**District:** Cherwell

**Application no:** 18/00077/DISC

**Proposal:** Discharge of Condition 8 (car parking provision) of 15/00153/REM.

**Location:** Heyford Park Camp Road, Upper Heyford, Bicester OX25 5HD.

HEYFORD PARK - HEYFORD PARK HOUSE CARPARK & TENNIS COURTS LAYOUT PLAN

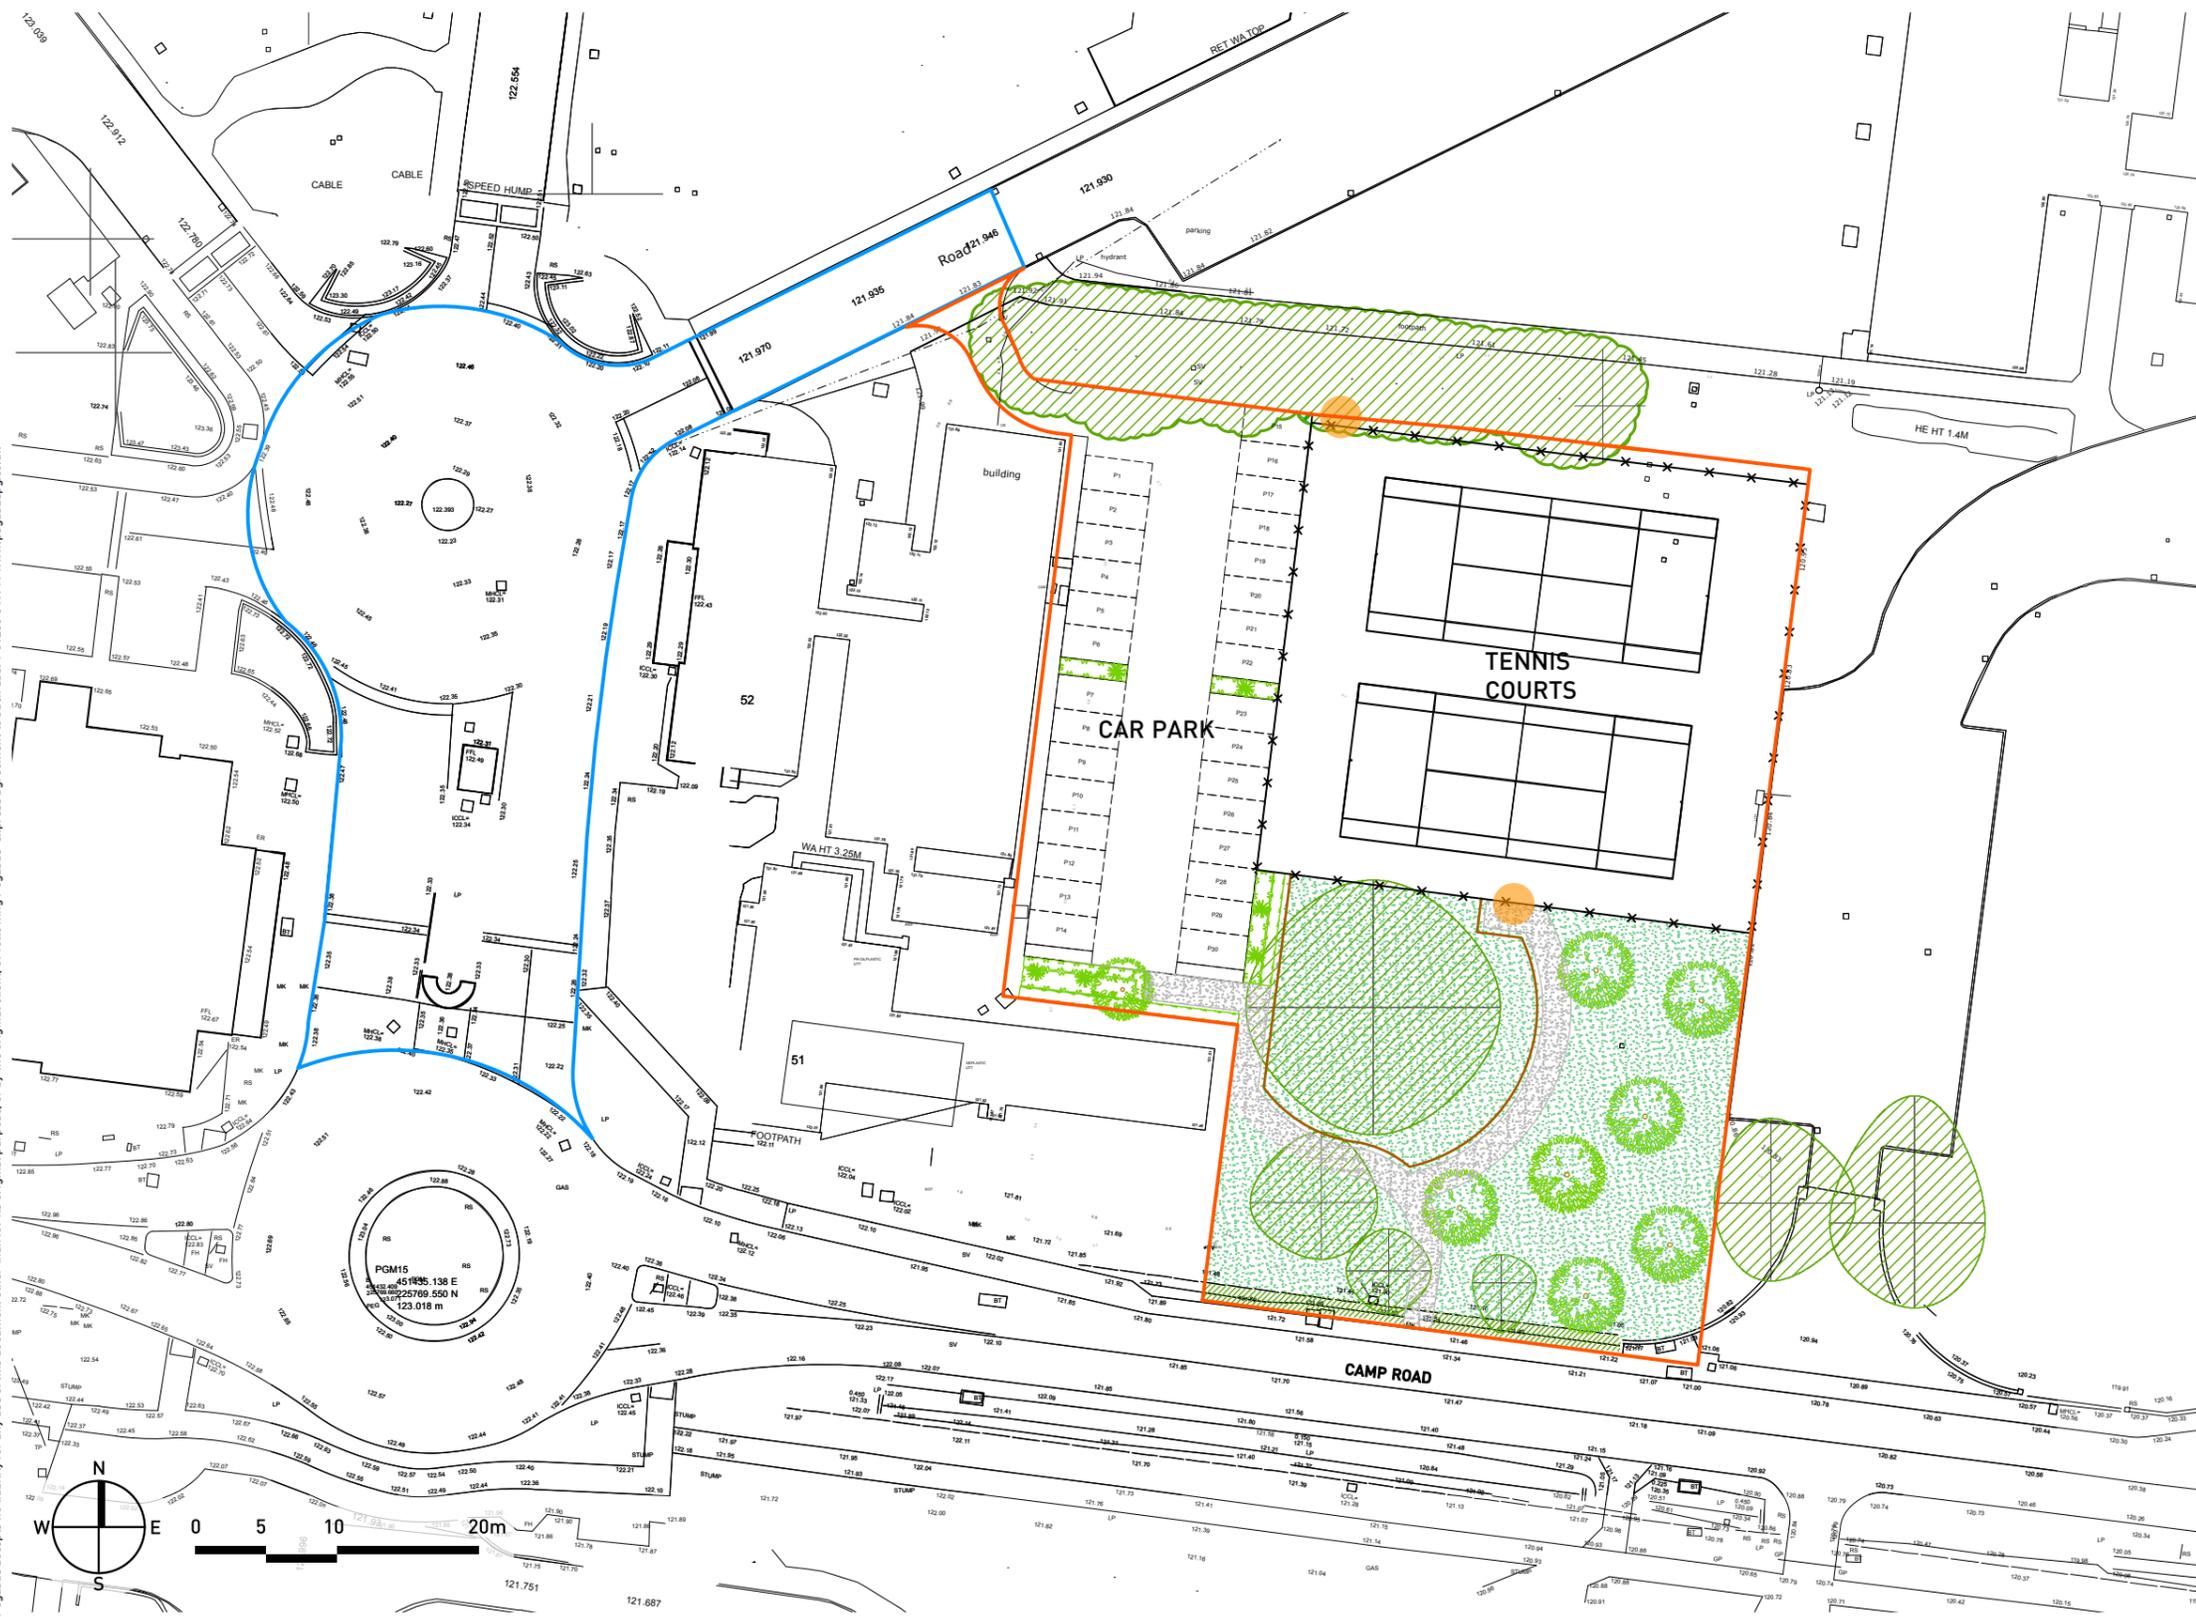
If this is an adoptable or adopted stretch of road then the parking bays are of a suitable layout for adoption. Bay No.1 is immediately opposite a road junction which could cause conflict, and the developer may choose to relocate this bay.

No details of drainage or surfacing are provided with the application documents. This information is required. **Reason for objection.**
